Welwyn Hatfield Borough Council  
Planning Department  
Council Offices  
The Campus  
Welwyn Garden City  
AL8 6AE

**Ref: 6/2022/2801/MAJ**

Thank you for consulting us on the submitted planning application for Campus East Car Park, College Way, Welwyn Garden City, AL8 6DG. Demolition of all existing buildings and structures followed by the erection of five buildings to provide 313 residential units (Use Class C3); car and cycle parking, cycle and refuse storage, hard and soft landscaping, external lighting, drainage, infrastructure and all associated works.

Title  
**FLAT BLOCKS G & H  
LEVELS 0, 1 & 2  
AFFORDABLE RENT**

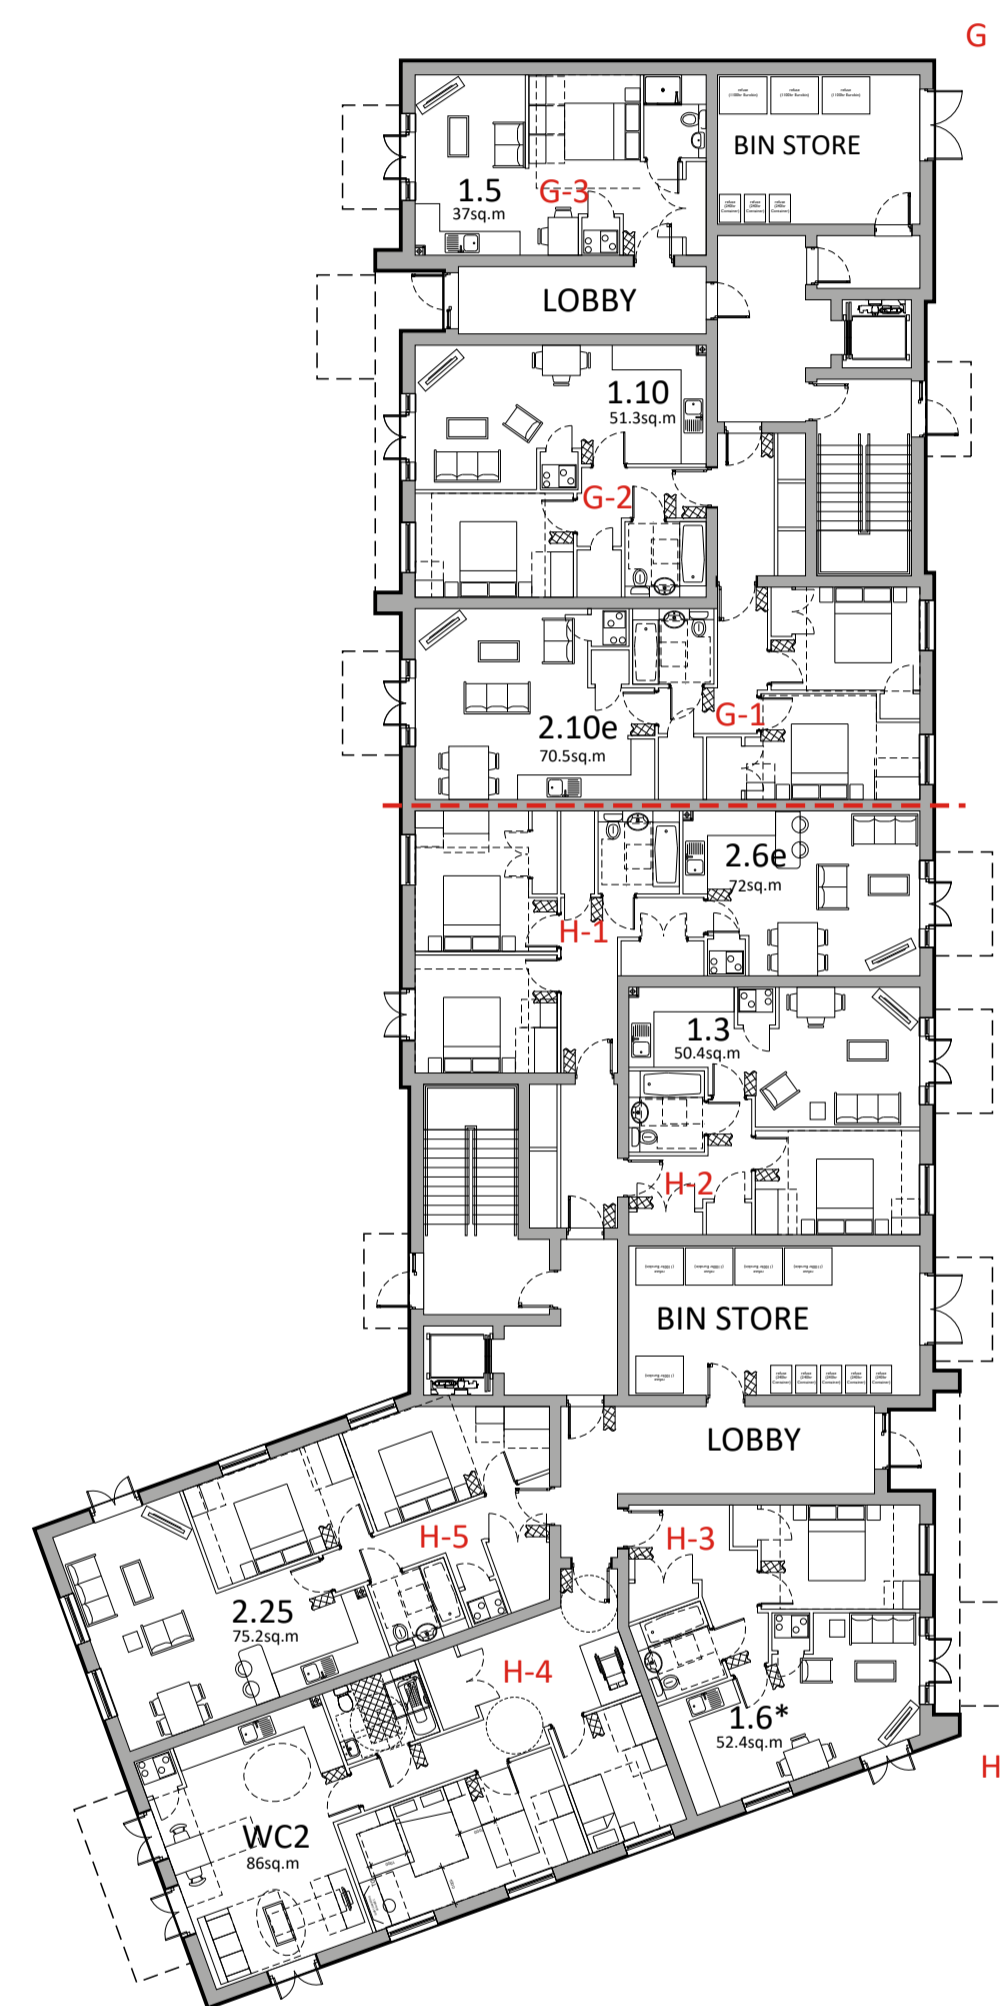
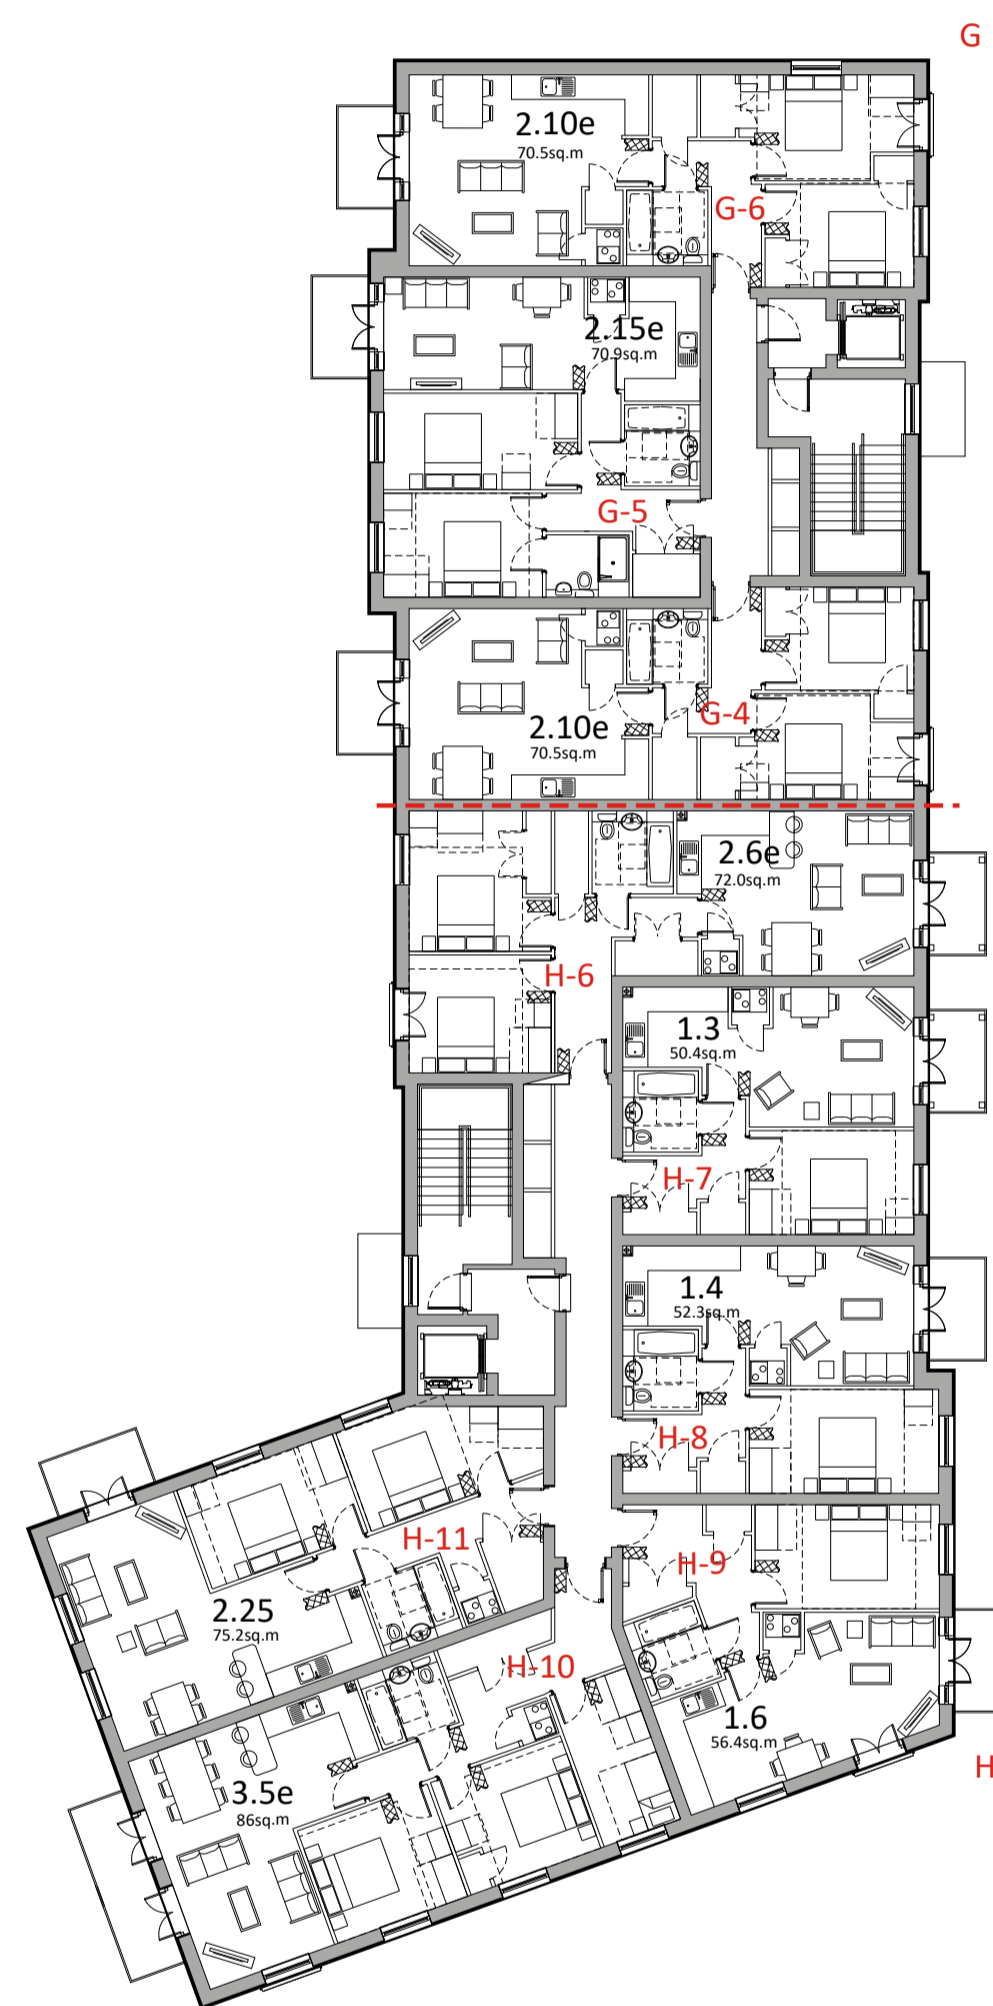
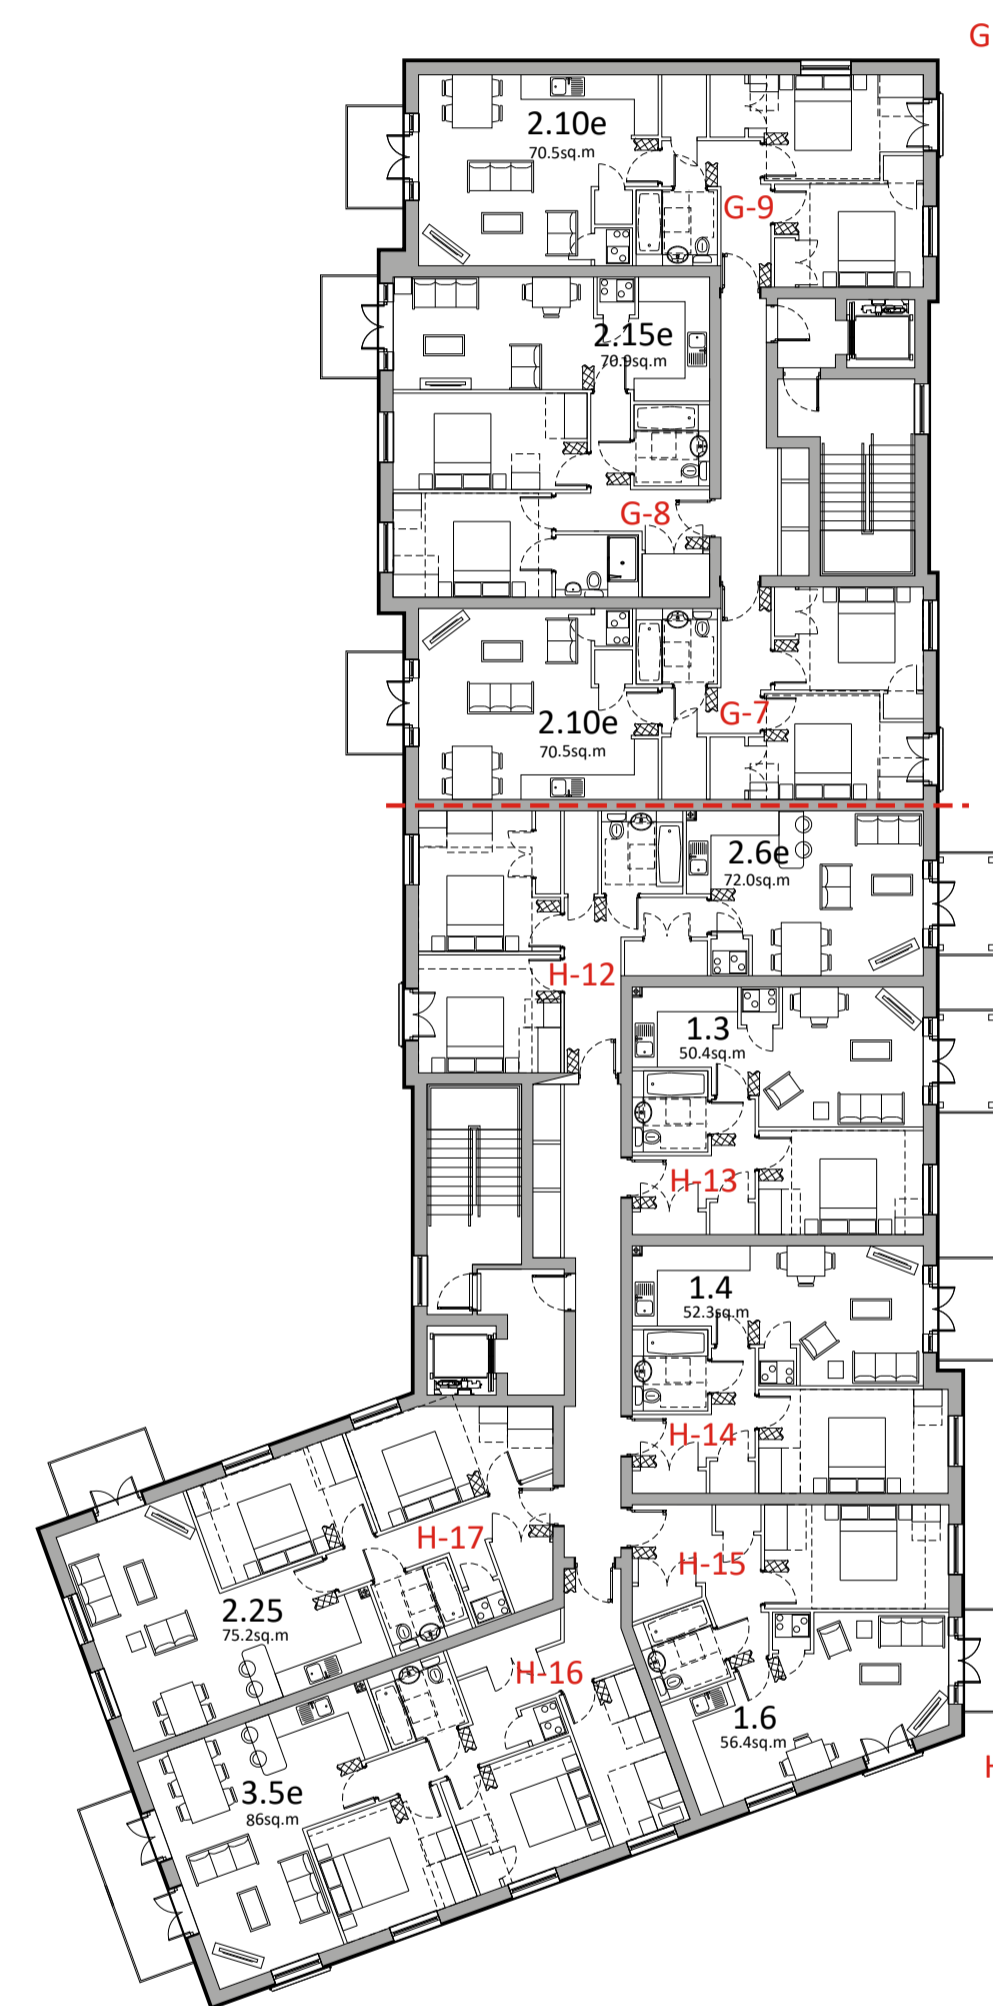
- Block H (end elevation fronting College Way) is a key building terminating the main vista into the development. This elevation lacks the architectural refinement and balance for such a key building, for example the position and design of the balconies applied to half of the frontage.

The use of projecting balconies on key frontages (as well as within the core of the development) remains an issue. The usability of these balconies on exposed and key frontages (such as Blocks H and B) is limited and will have a negative impact when considering the end user and the potential for storage. Recessed and integrated balconies would be a preferred.
